MINSMERE LEVELS STAKEHOLDERS GROUP

Proposed development of Sizewell C Power Station by EDF Energy. Observations on the Stage Three Public Consultation

Response to the Third Stage Consultation of the Proposed Development of Sizewell C Nuclear Power Station

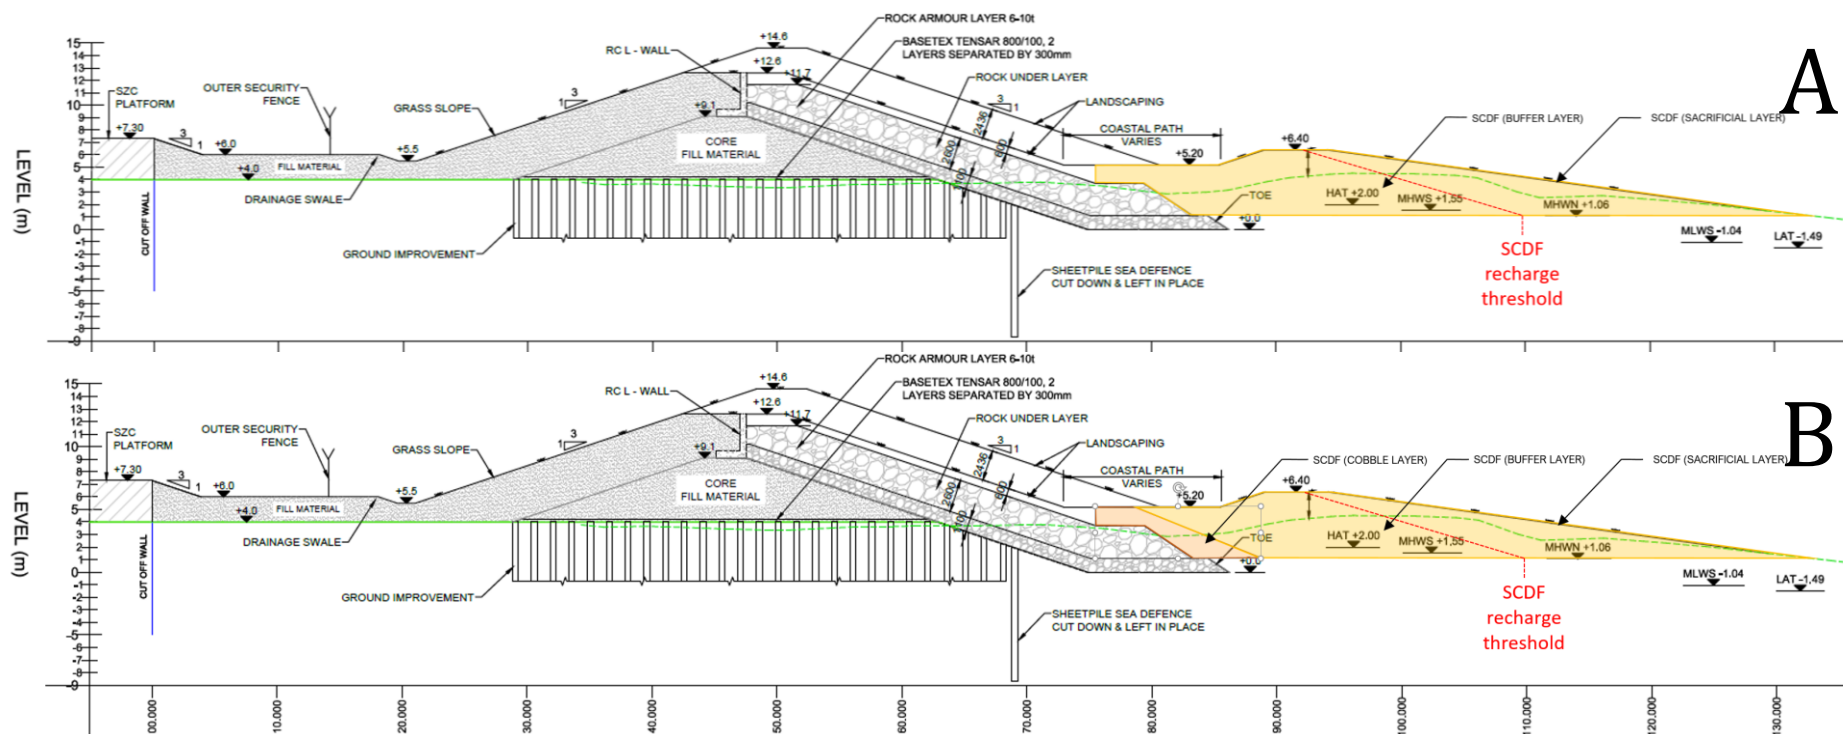
15. The HCD shown in the Stage 3 documents hasn't changed since Stage 2. It is currently described as armoured with rock with the toe at 0-1m AOD and topped by a bund. However, with Minimum Spring Low Tide (MSLT) levels at -2.1m (EN-6 Appraisal of Sustainability Report for Sizewell) this leaves the HCD toe >3m above MSLT. Current accepted design criteria require the extension of the toe to below MSLT. At the current 1:3 slope design, this would require the toe to move east by at least 10m, well beyond the current edge of the existing sacrificial dune and into the beach.

17. Extensions of the HCD toe to below MSLT would also result in the HCD being uncovered earlier than currently expected in Stage 3 documentation and present a new and extensive hard point on coast affecting sediment transport both north and south of the SZC site.
